REVISION/DEFERRED SUBMITTAL FORM

Site Address 7450 N Mercer Way

Permit Number 1904-048

Removal of two cedar trees along west property line.
Refer to Delta '6' for revision.

L-2.0

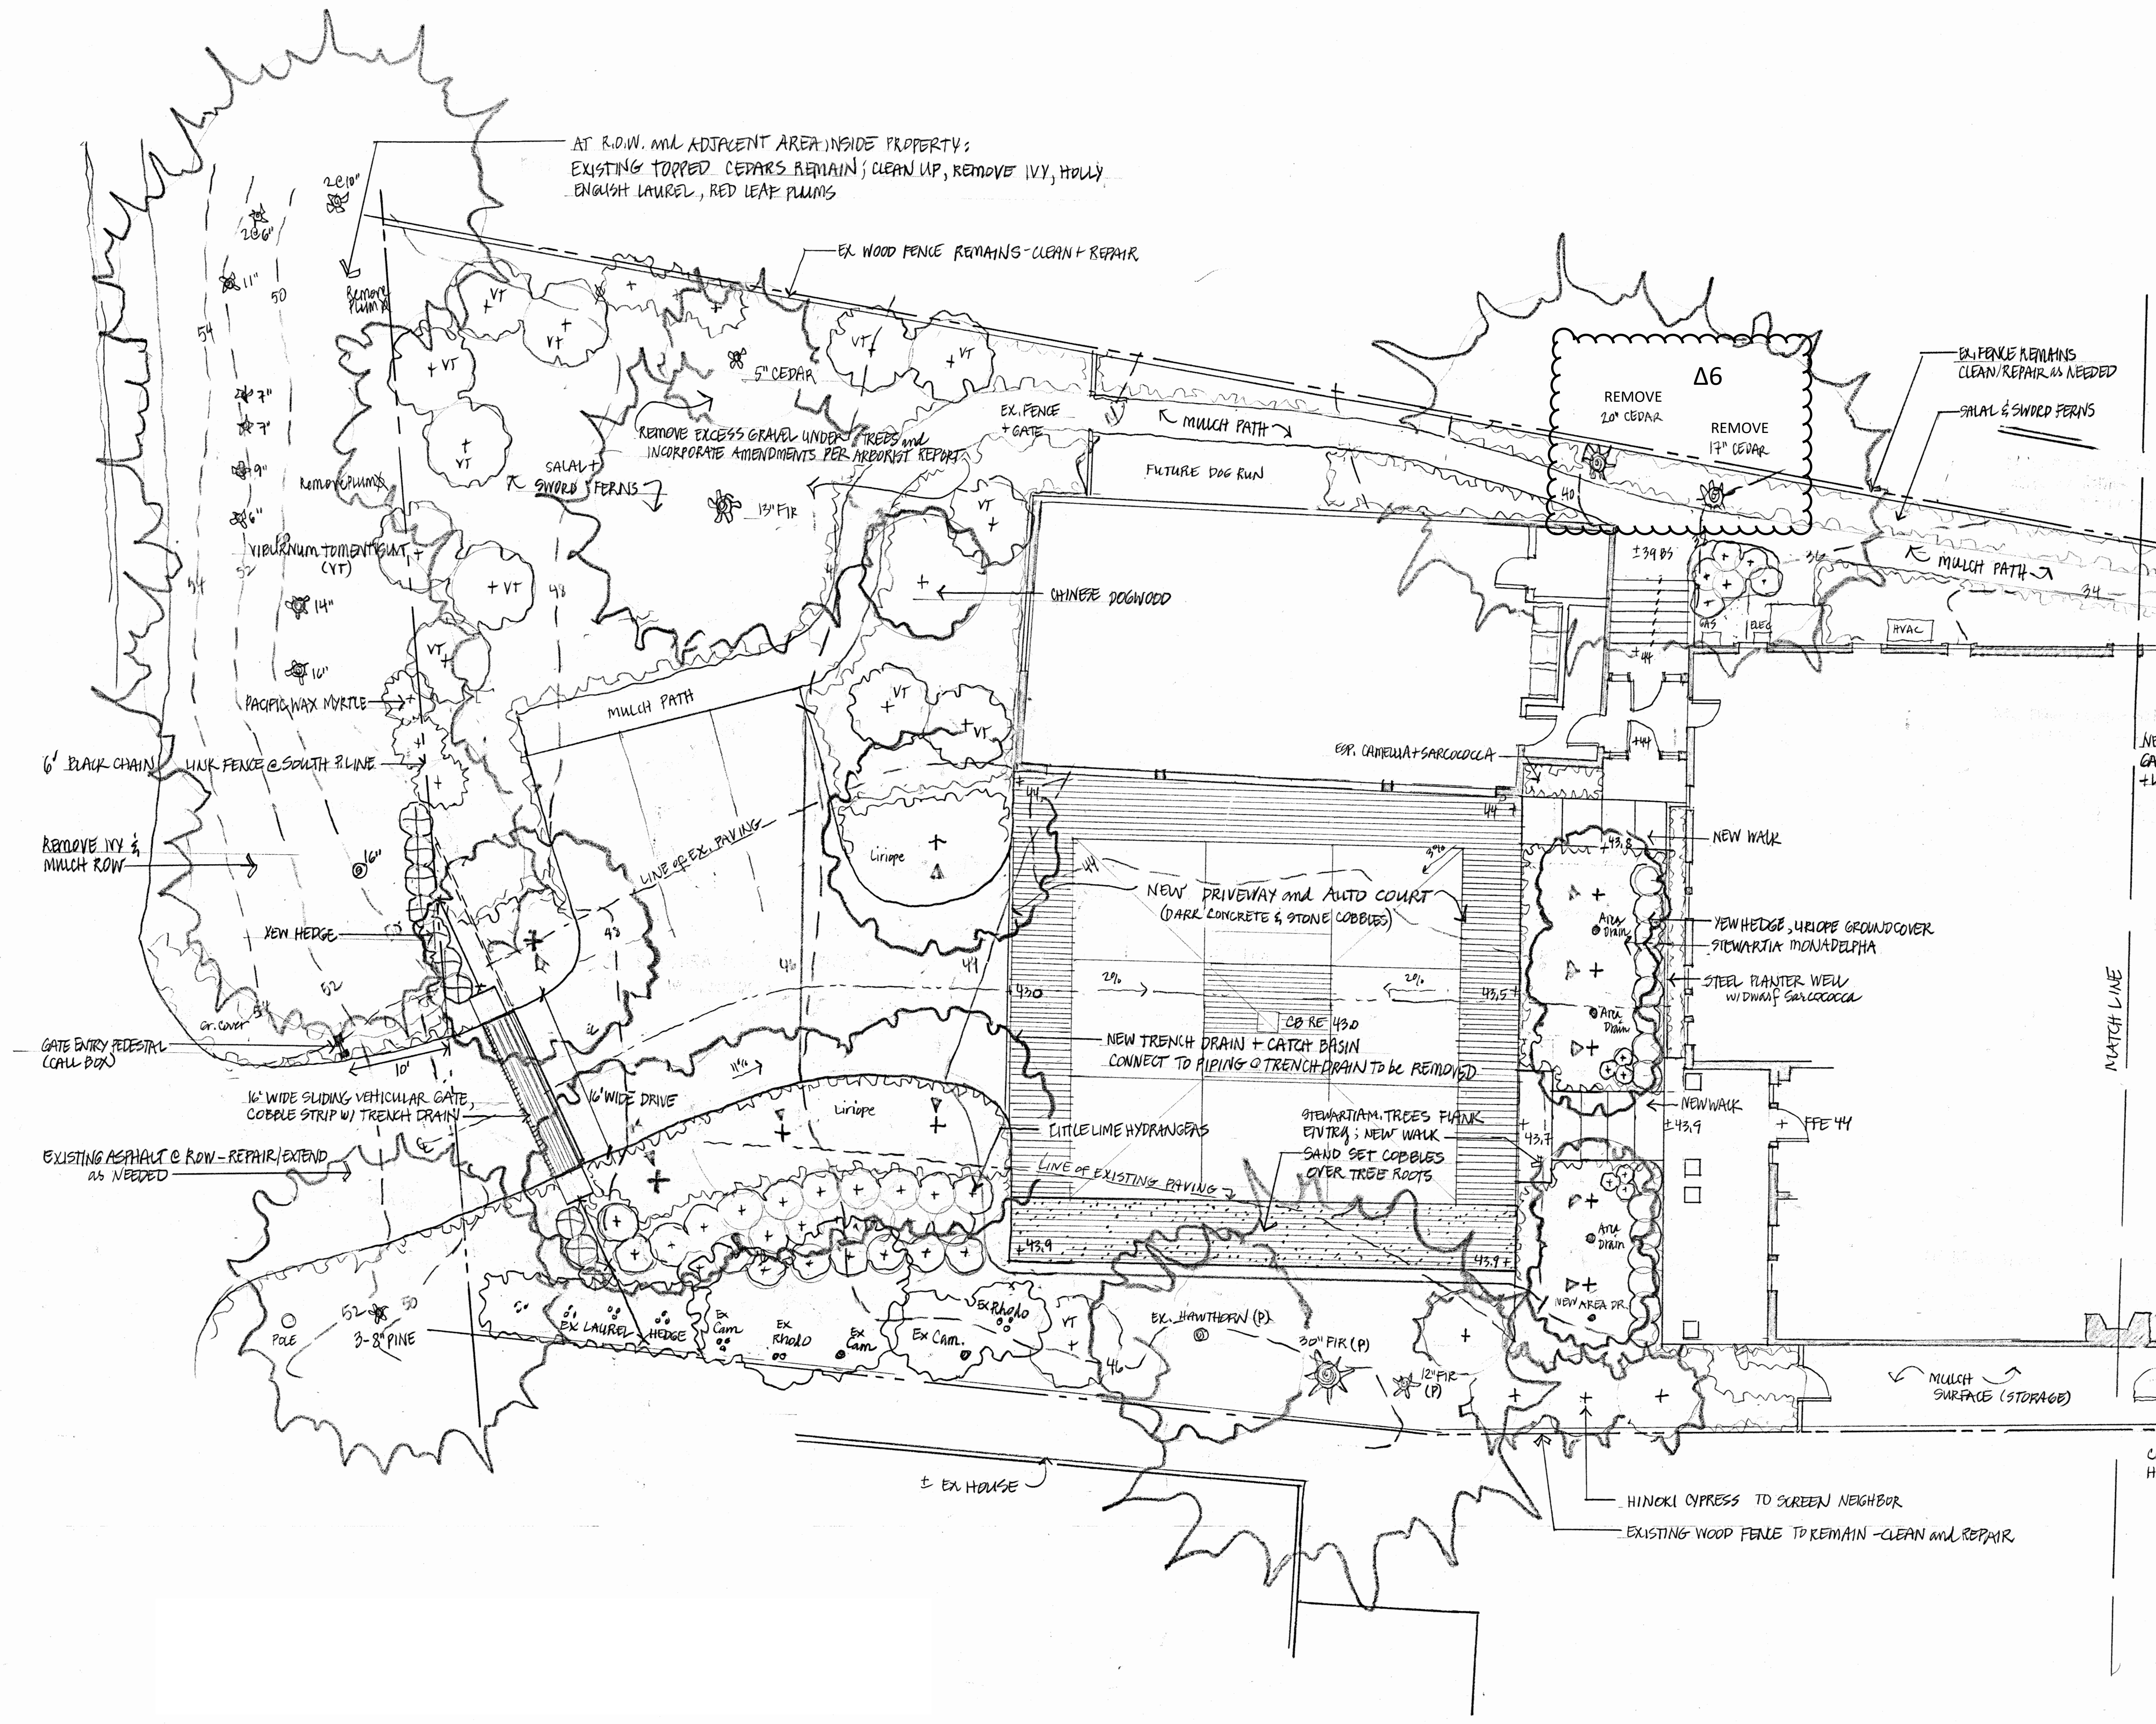
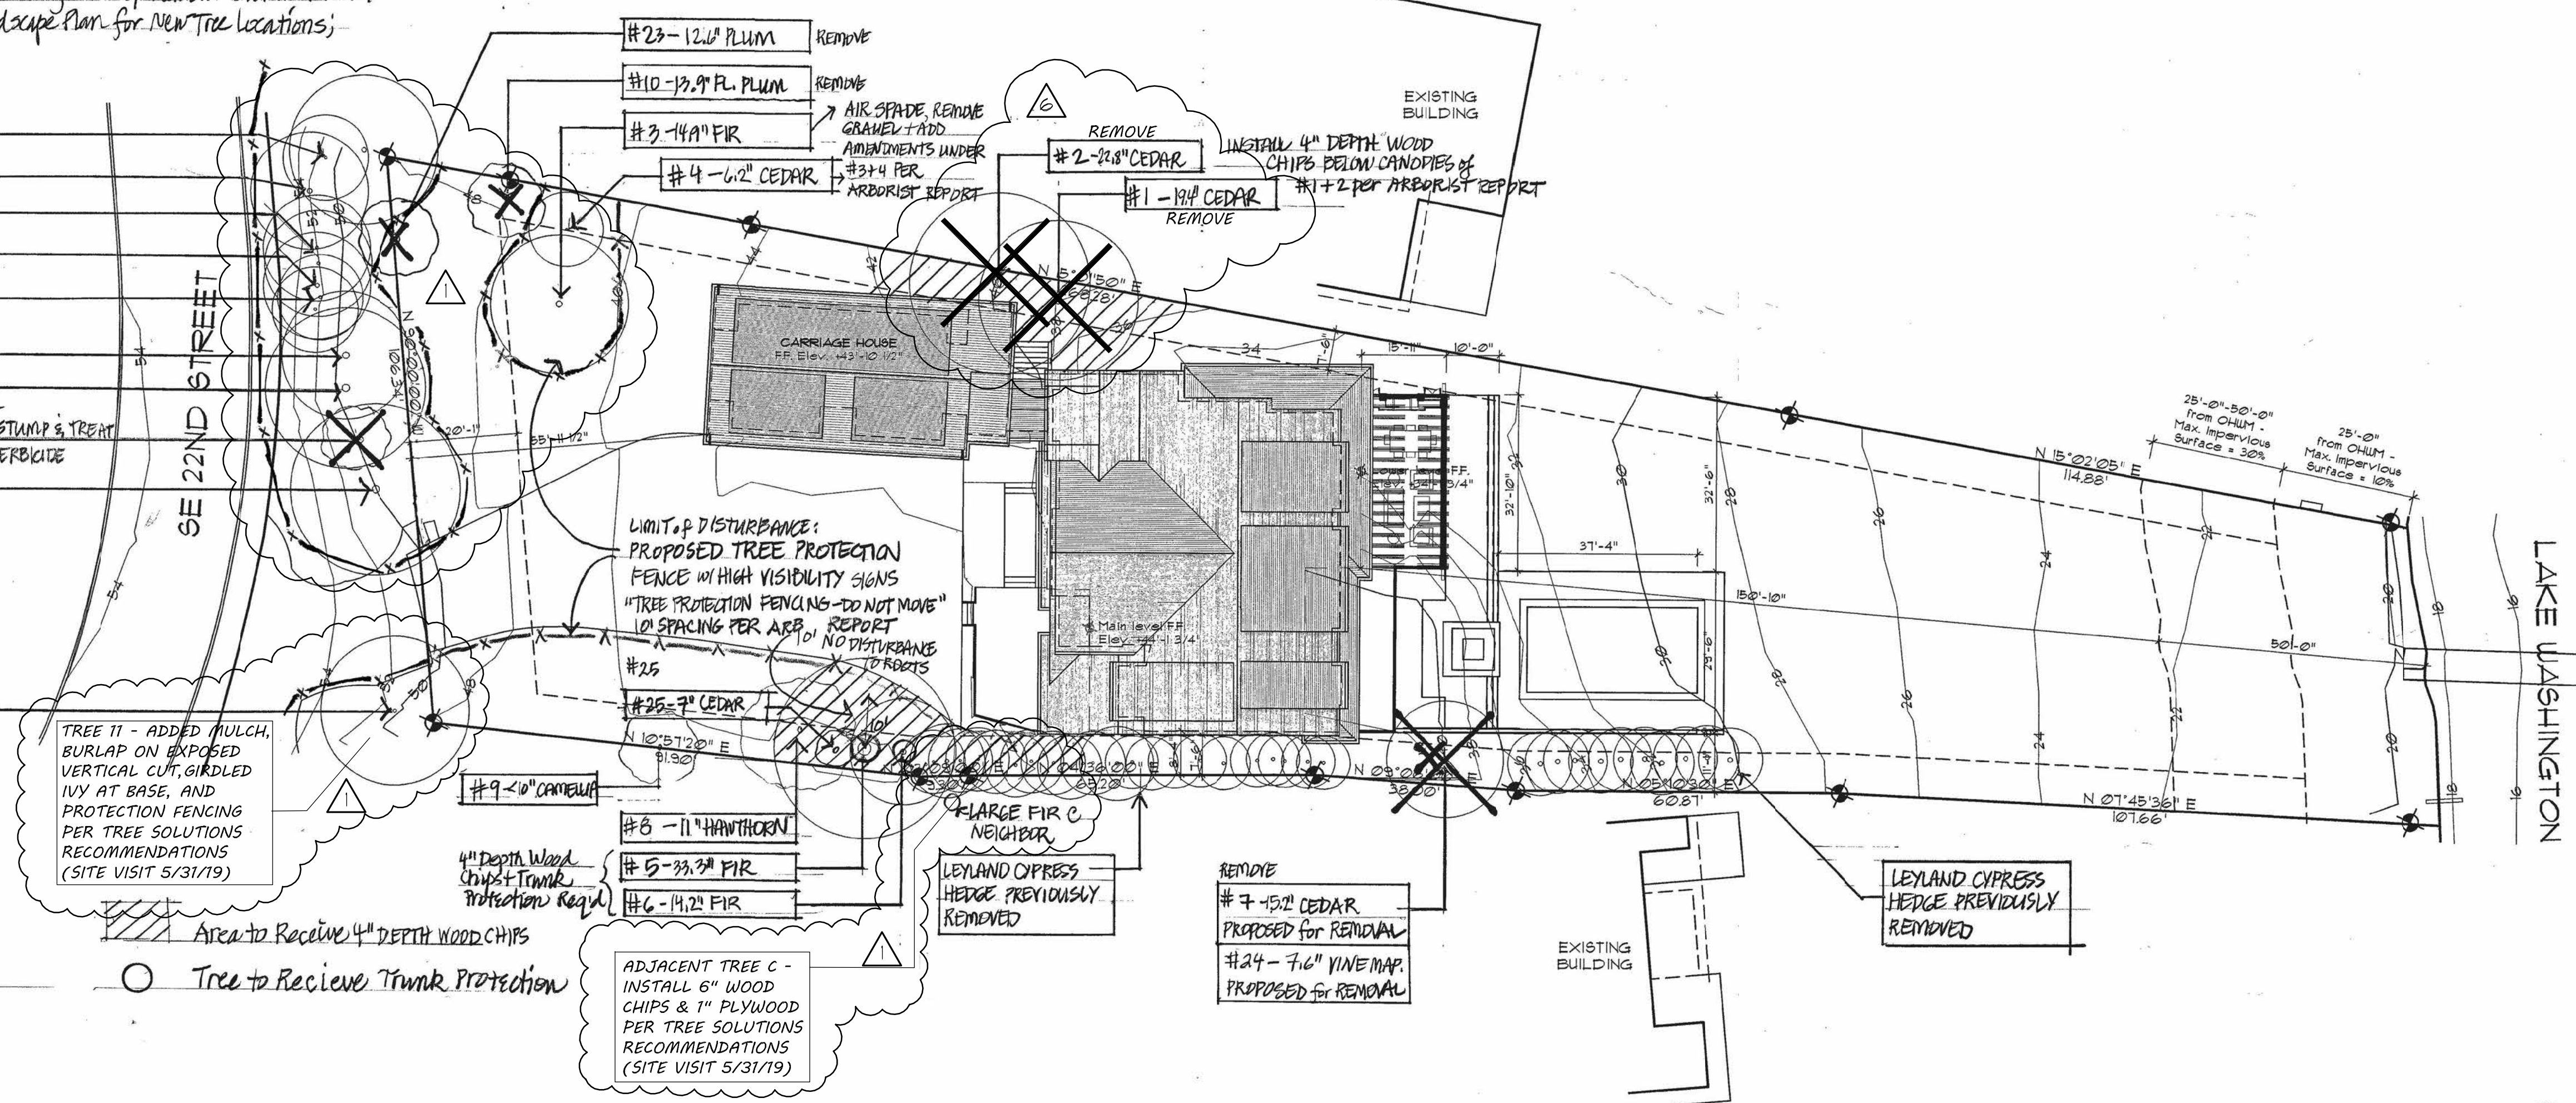
Sheet #	A-1.1	Two cedar trees along west property line marked for removal.
Sheet #	L-1.0	Two cedar trees along west property line marked for removal.
Sheet #		(Tree Inventory diagram has been updated accordingly)
Sheet #	L-2.0	Two cedar trees along west property line marked for removal.
Sheet #		
Sheet #		
Sheet #		
Sheet #		
Sheet #		
Sheet #		
Sheet #		
Sheet #		
Sheet #		
Sheet #
